Inspector's Report ABP-316057-23

Development	Section 254 Licence for a wireless broadband and data communication steelworks pole to address identified mobile and wireless broadband coverage area blackspots.
Location	Grass Verge on Carrignafoy Avenue/East Hill, Carrignafoy, Cobh, Co. Cork.
Planning Authority	Cork County Council.
Planning Authority Reg. Ref.	S/254/3/2022
Applicant(s)	Emerald Tower Limited.
Type of Application	Section 254 Licence.
Planning Authority Decision	Refuse Licence.
Type of Appeal	First Party.
Appellant(s)	Emerald Tower Limited.
Observer(s)	None.
Date of Site Inspection	14 th August, 2023.

Title: PTI SMART STREETPOLE SITE LAYOUT PLAN

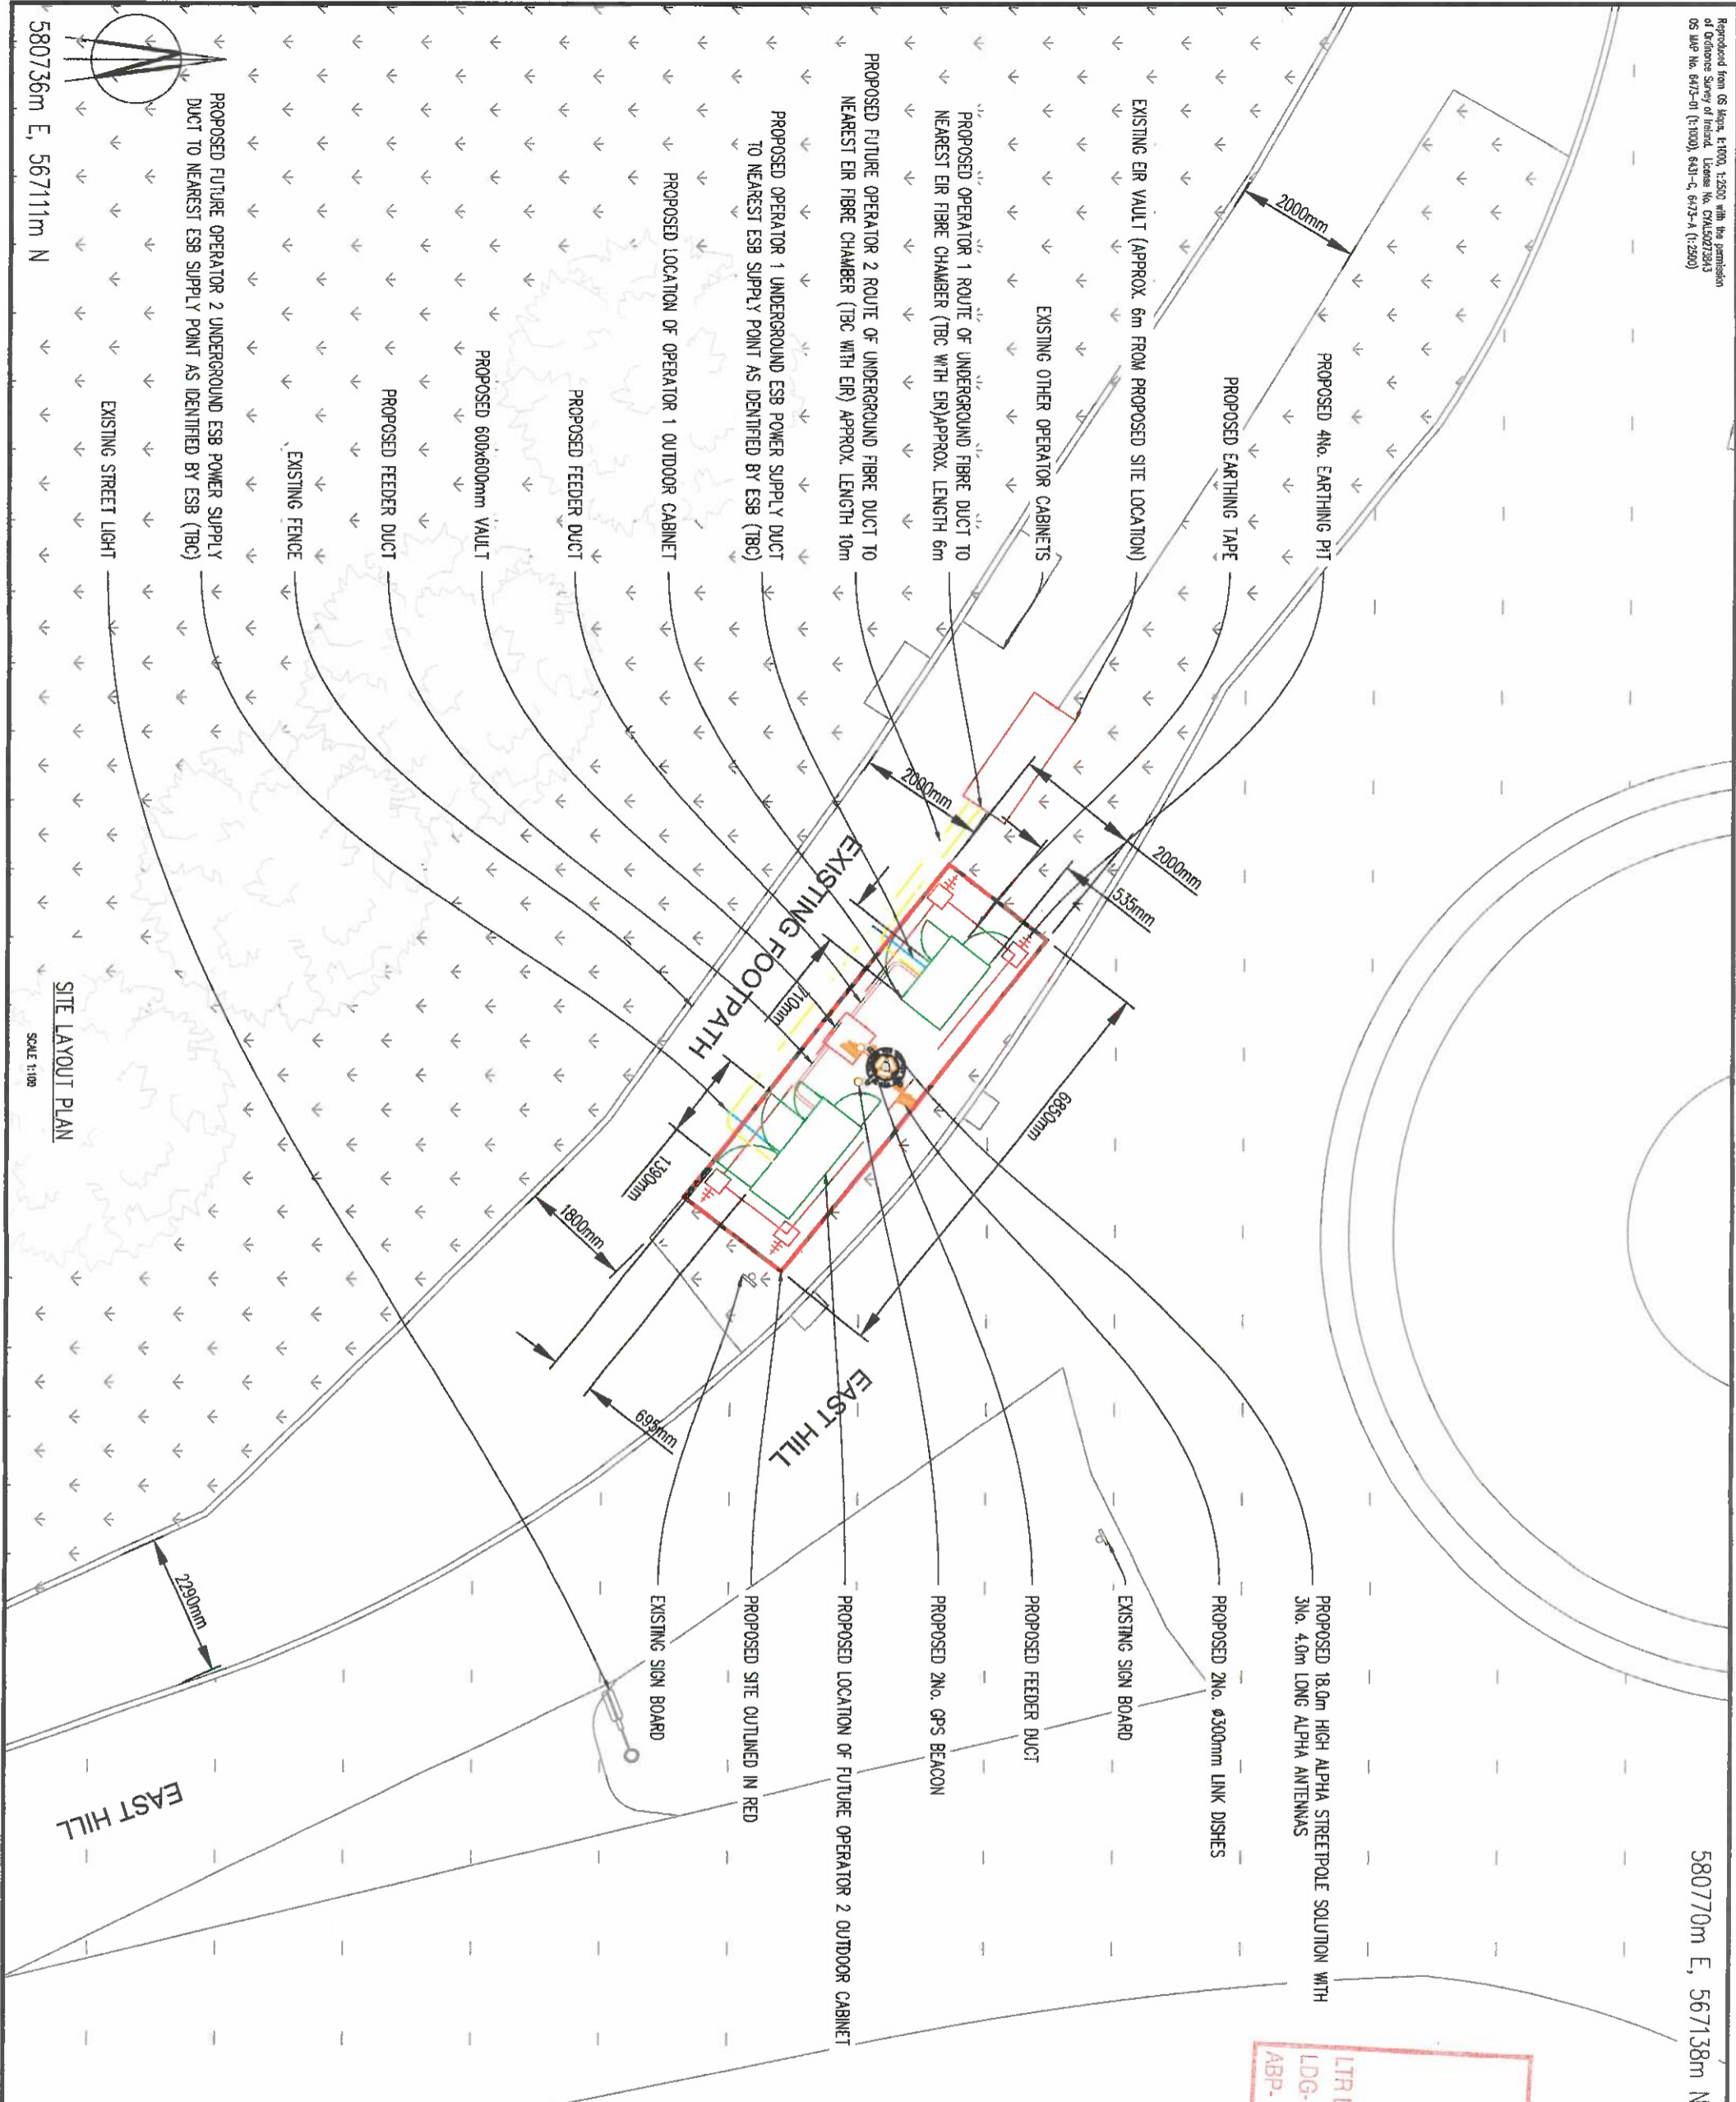
6.3.5 I would, however, be of the opinion that the proposed development, once operational, is likely to obstruct sightlines on approach to the Velvet House Cross Roundabout from East Hill to the south. The Proposed View of Viewpoint 4 demonstrates that the full extent of the road network off the Roundabout, and Stop sign on the same verge as the proposed development on the East Hill approach to the Roundabout, are partially obscured by the 2no. cabinet structures, 1.65m in height each, cumulatively with the pole.

6.4.5 However, the applicant has not provided any justification as to why the location previously suggested by the Area Engineer, in the open space area to the west of the proposed development site, is not suitable.

6.4.6 This open space area is sufficiently large to accommodate the proposed development with only a minor reduction in the provision of open space for O'Neill's Place residential area.

6.4.7 There are already 2no. cabinets and a street lamp post located adjacent to the fence that bounds this open space area, meaning that the proposed development would be accommodated at a location where there are existing utilities.
